From: Simon Davis
Sent: 14 June 2019 12:41
To: Planning.Responses
Subject: FW: Y/48/19/DOC - Cinders Lane Nursery and works to the rear Cinders Lane, Yapton, BN18 0JJ
Attachments: 19.14.102 C Site Wide Elements.pdf
Importance: High

Further to my email sent earlier today, please refer to the email below from my client and the attached Site Wide Elements Plan ref. 19.14.102C, which you should substitute for the version currently lodged.

Please find attached an amended site wide elements plan following comments from environmental health.

Construction Method Statement

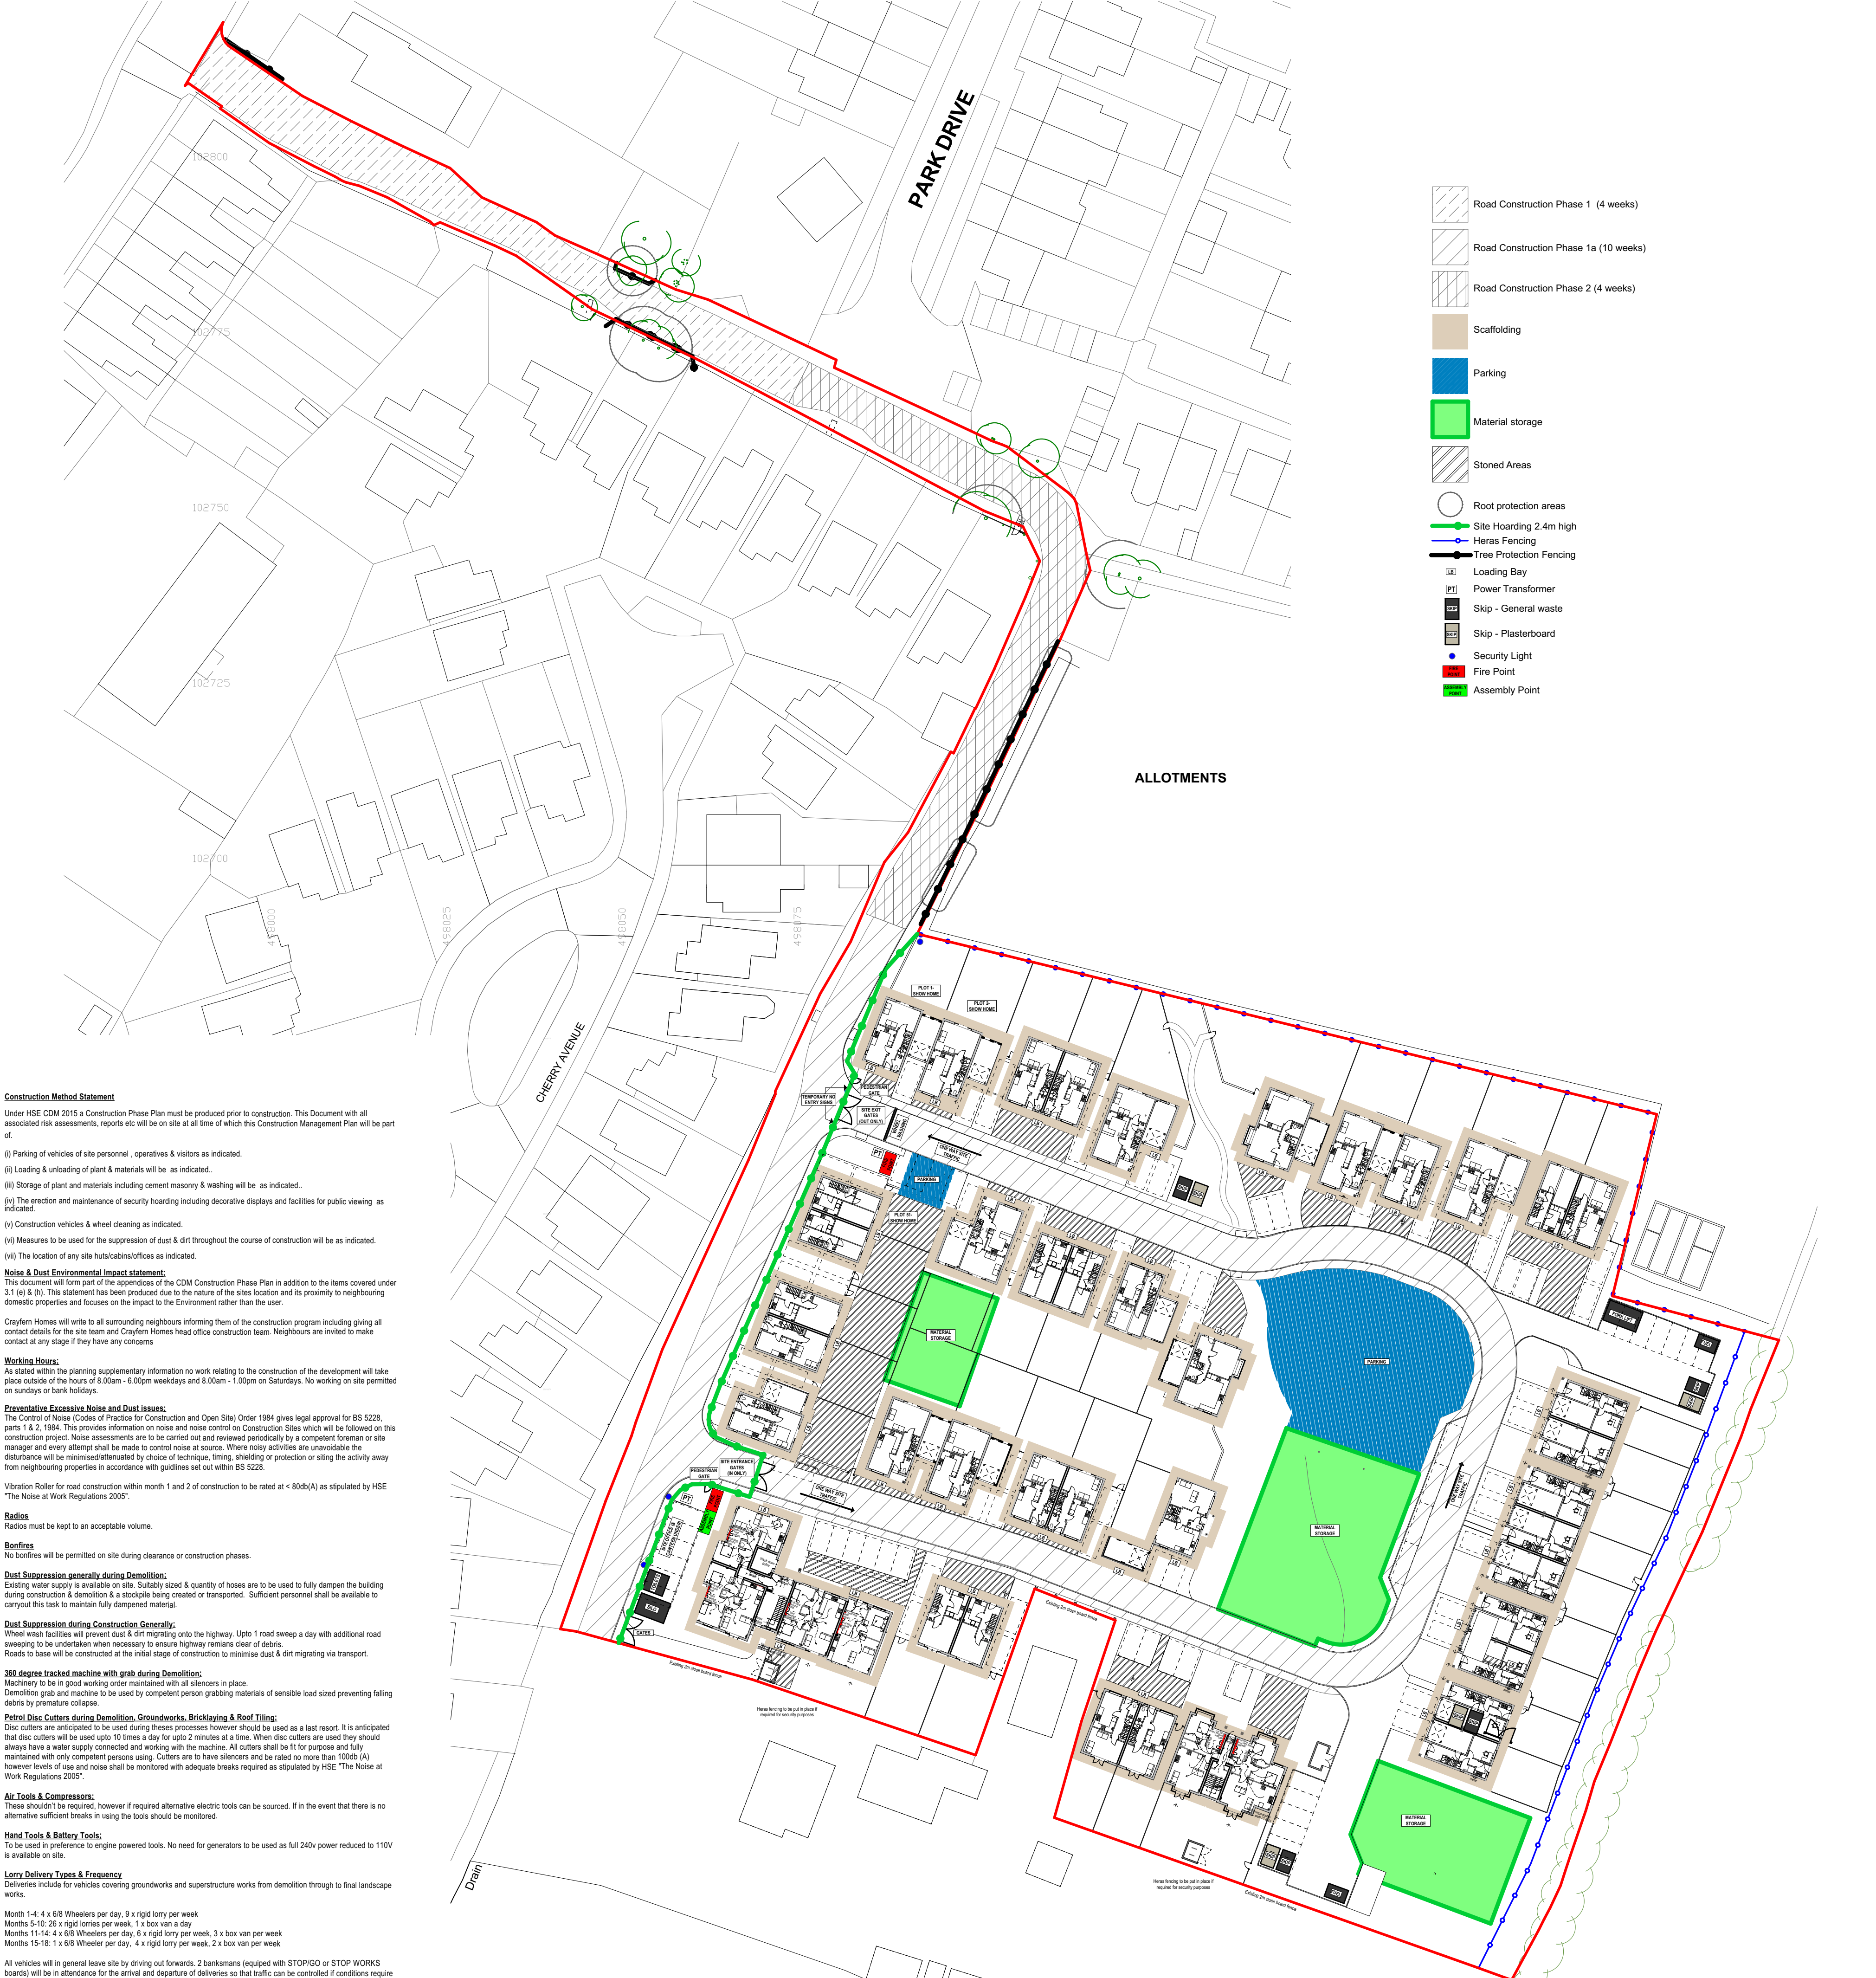
A slight oversight on our part but we shouldn't have shown heras fencing to the south boundary where it adjoins residential property. There is an existing 2m close board fence to this boundary and we would only put up heras fencing if required for security purposes. This has now been noted on the drawing and the heras fencing removed.

Also, the drawing now shows the site to the south as per the existing layout and does not show anything indicating the potential residential layout following their outline planning permission.
